Flat 4, 129 Camberwell Rd. SE5 0HB

Proposal number: 2006

DESIGN AND ACCESS & HERITAGE STATEMENT (WITH SCHEDULE OF WORKS)

8. Preplanning Enquiry Recommendations and Responses - Southwark Council reference 22/EQ/0055

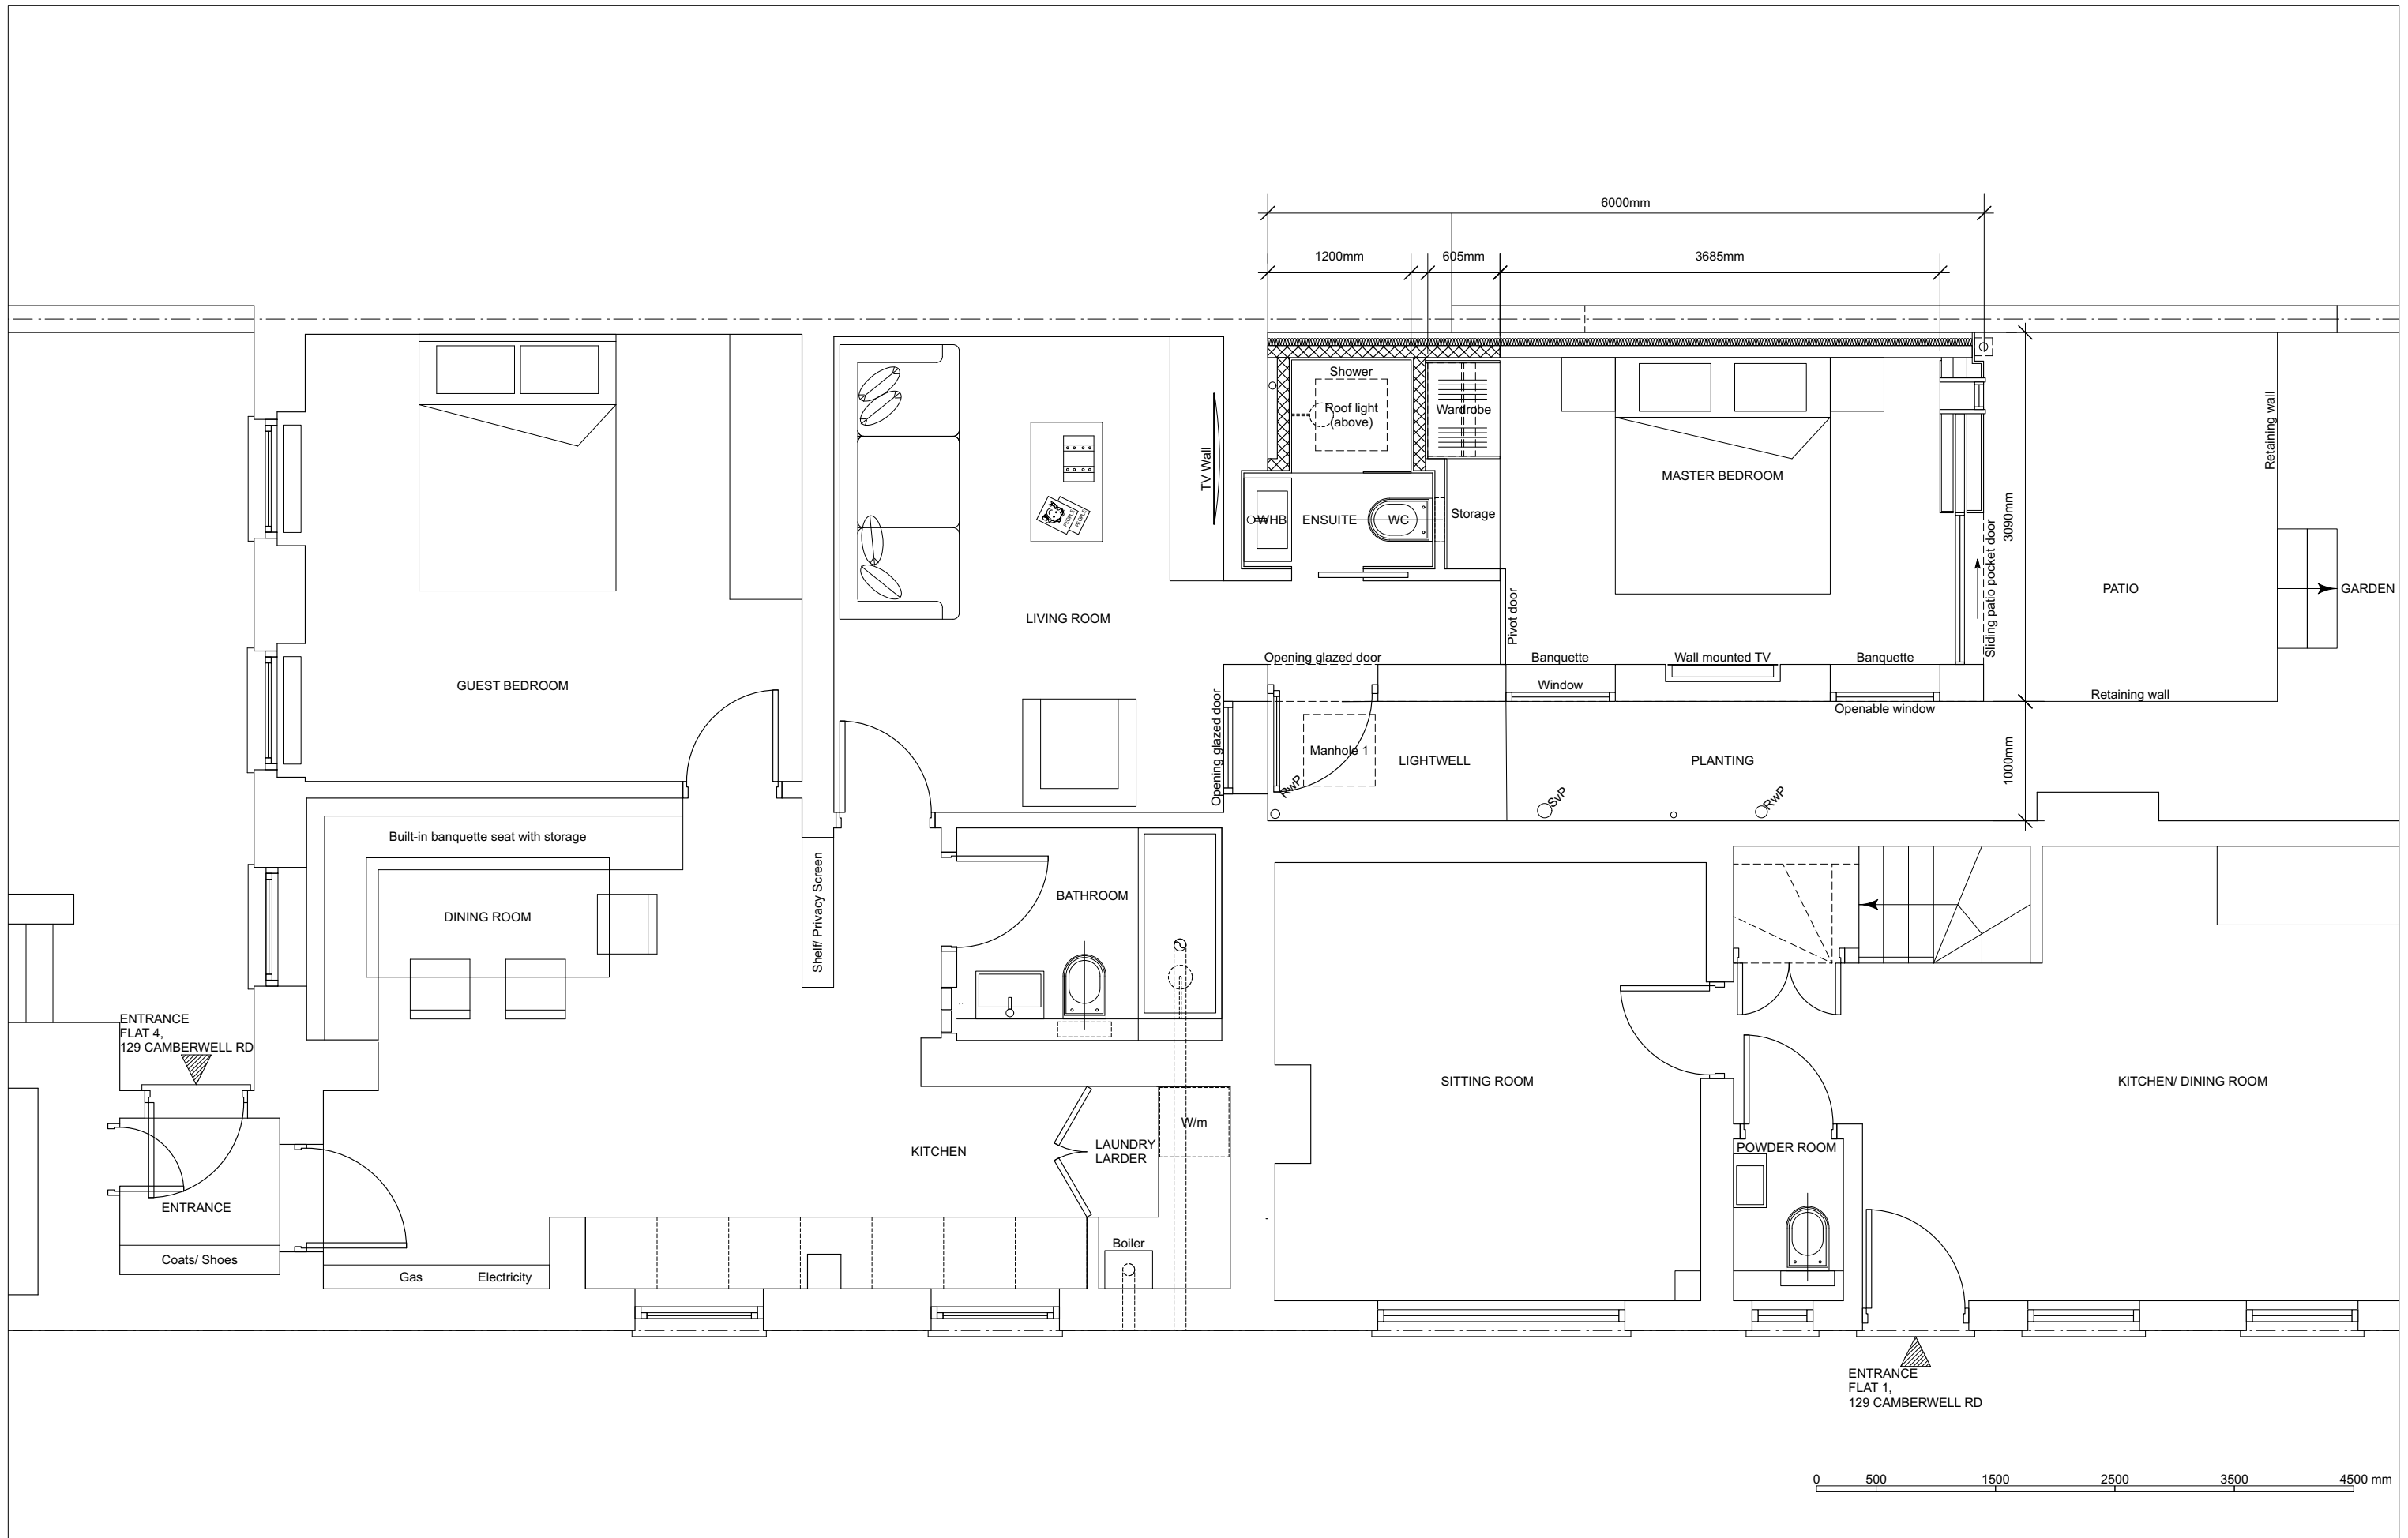
"The proposed ground floor rear extension will create similar views to those that already exist. No. 54 Addington Square does not have any windows on the side elevation, however, does have a truncated window; however, it is unlikely that the proposal will cause loss of privacy to neighbouring properties. The proposed roof lights would create upward facing views and is unlikely to cause a loss of privacy." We have reduced the amount of glazing along the rear facade and also eliminated one of the roof lights.

"It is however noted that the extension would have a very awkward relationship with the adjacent outrigger, with only a very narrow gap between them. The extension should either abut the outrigger or else have a decent separation from it (at least 1m). In addition, the proposed extension will compromise the layout of the house by creating an internal living room with no windows and no direct access to natural light. This is contrary to Policy 2.5 – Internal layout of dwellings of the Technical update to the Residential Design Standards SPD and is not acceptable." To address the issue of natural ventilation and daylight to the internal living room we took on board Southwark Council's recommendation to set back the new extension from the outrigger extension to the neighbouring property by 1m. In this setback we will provide an openable window/ door for lighting, ventilation and access. There will be additional windows for lighting and ventilation in the corridor outside the Shower Room leading to the Master Bedroom. Also this space can be used as an intimate garden with planting that can be viewed from both the Living Room and the Master Bedroom.
